Development Facilitation Team (DFT) – Review Comments

Project No: PR-2021-005597 Date: 5/21/2025 Agenda Item: #9 Zone Atlas Page: G-11

Request: Re-divide existing lot 9-A and 10-A into two new lots and grand additional sidewalk easements

Application For: MINOR_PLT-2025-00022-PRELIMINARY/FINAL PLAT

PLAT OF
LOTS 1 THRU 10
THE UNIVERSITY OF ALBUQUERQUE
URBAN CENTER
 WITHIN
 THE TOWN OF ATRISCO GRANT
 IN
 PROJECTED SECTION 2, TOWNSHIP 10 NORTH, RANGE 2 EAST
 NEW MEXICO PRINCIPAL MERIDIAN
 CITY OF ALBUQUERQUE
 BERNALILLO COUNTY, NEW MEXICO
 NOVEMBER, 2021

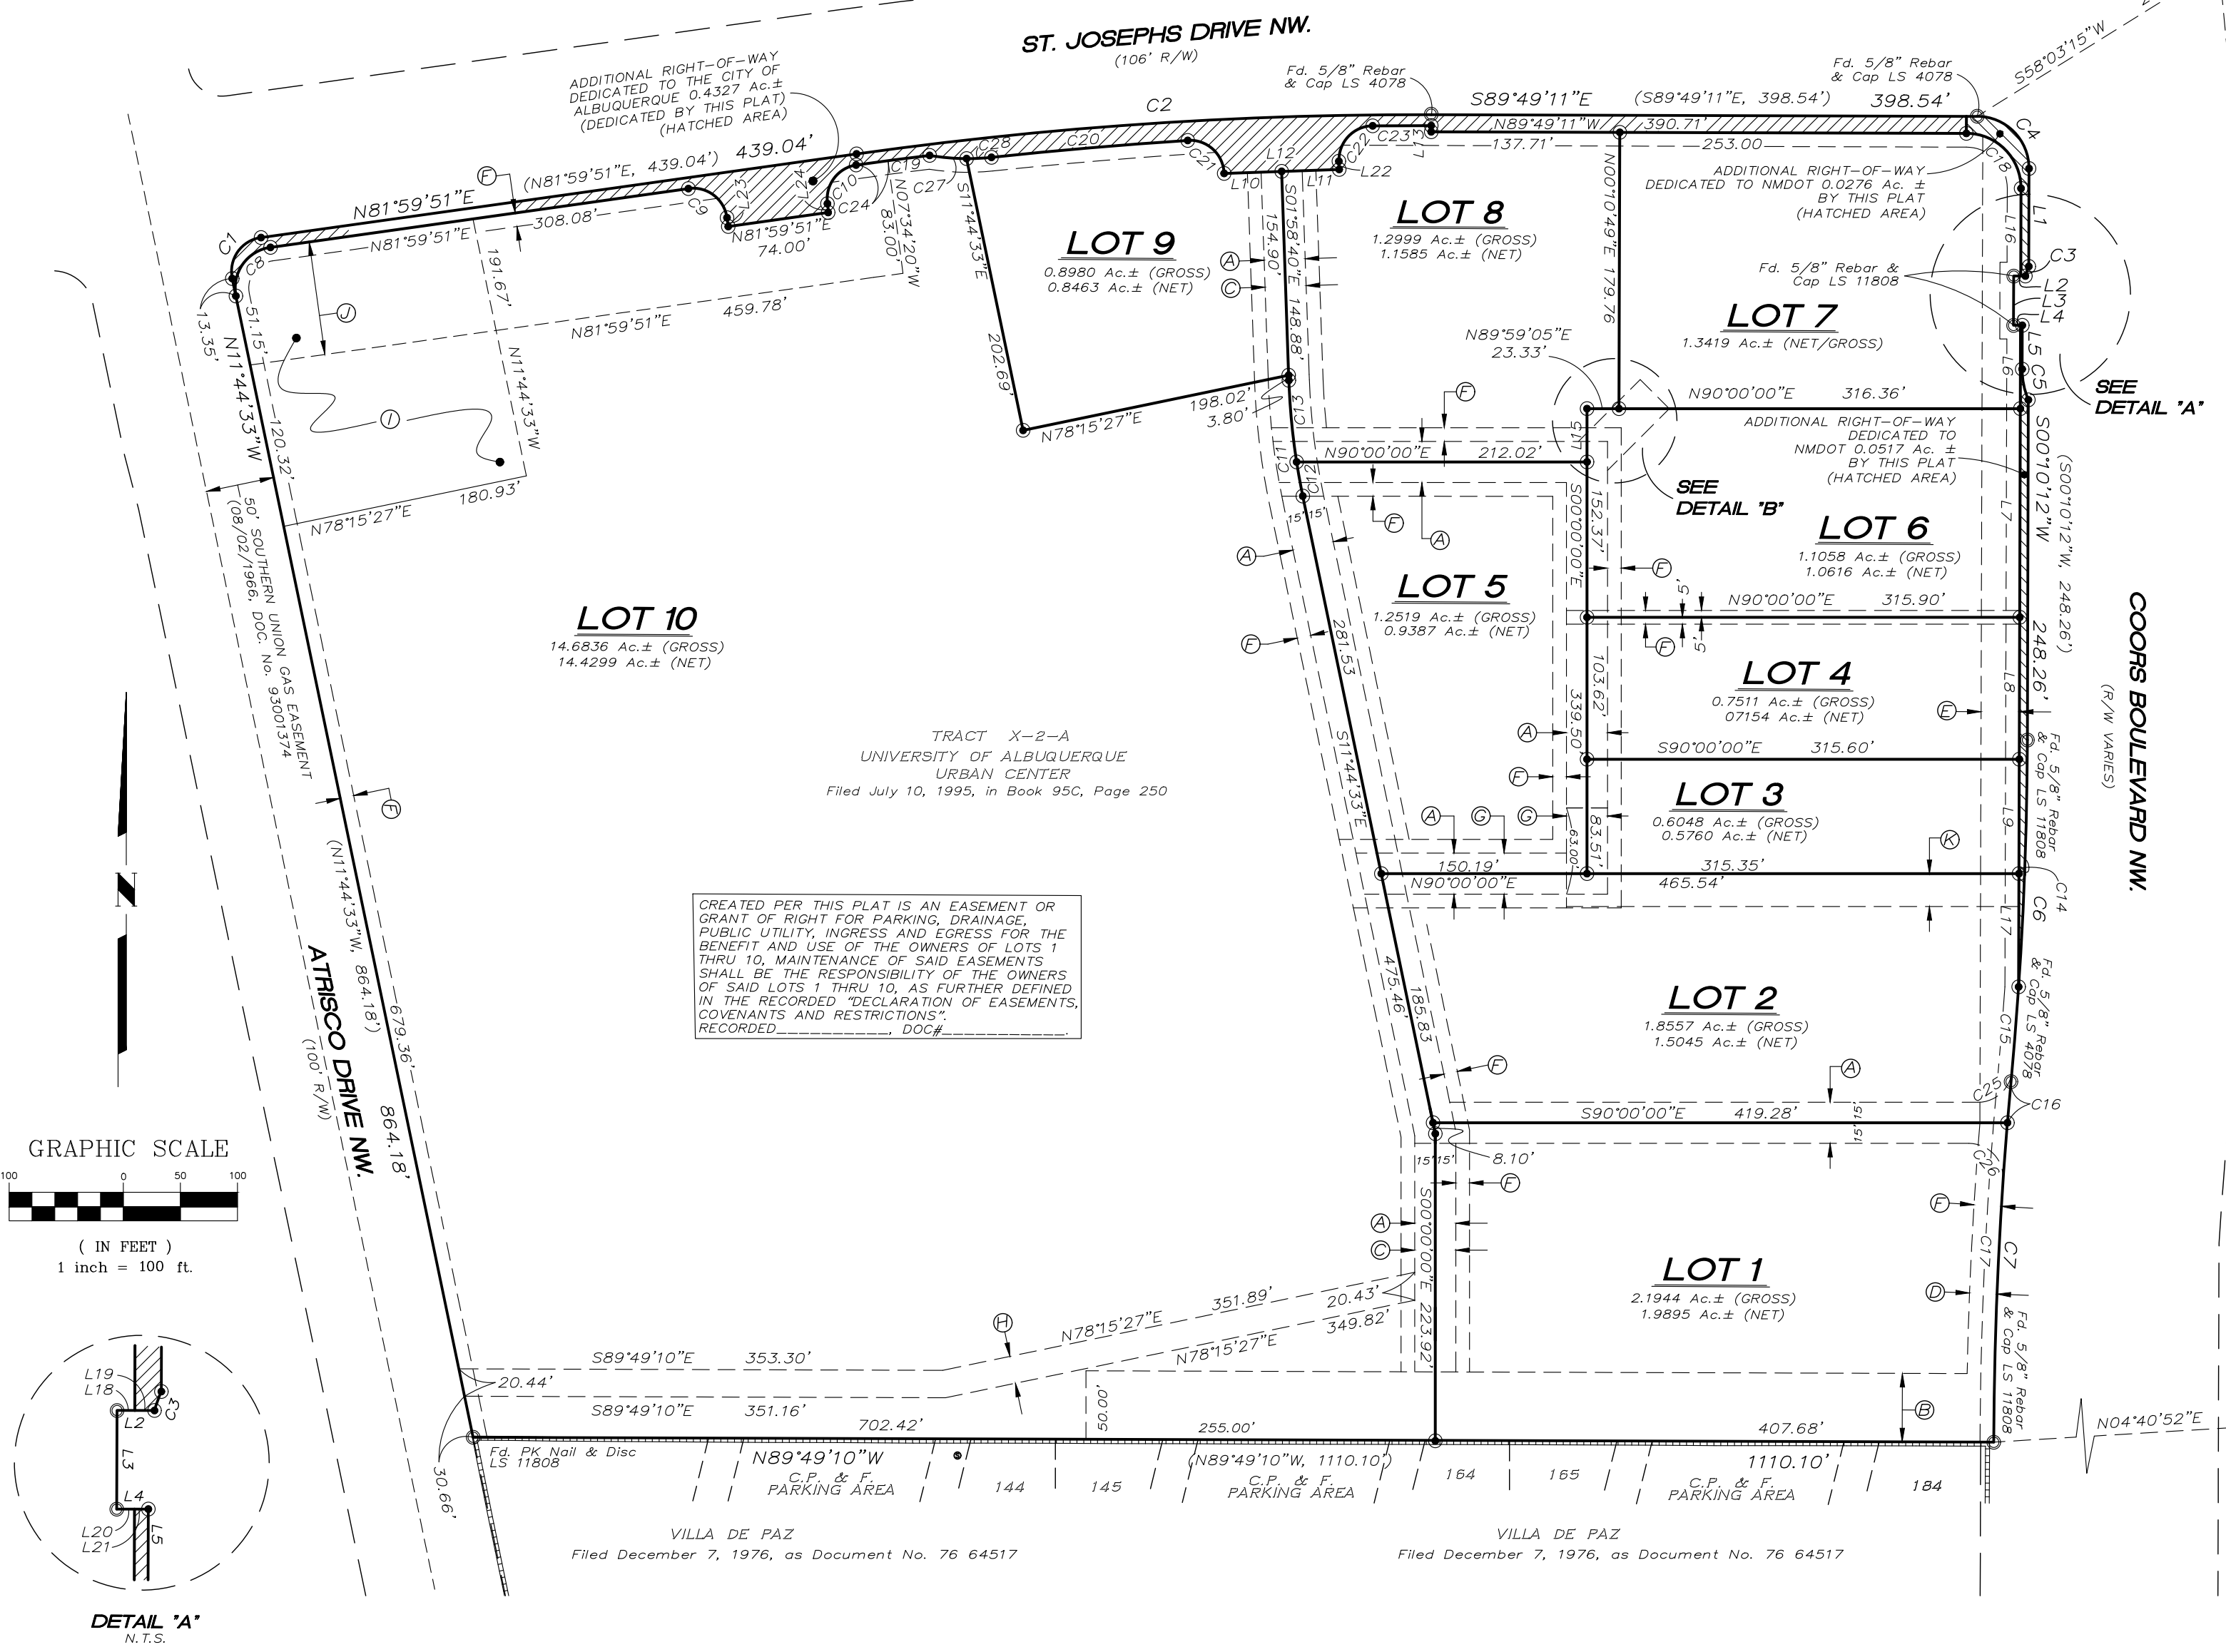
1. Please revise easement (A) to also call out “PUBLIC” Sanitary Sewer also. e.g. “Public Water and Public Sanitary Sewer”...
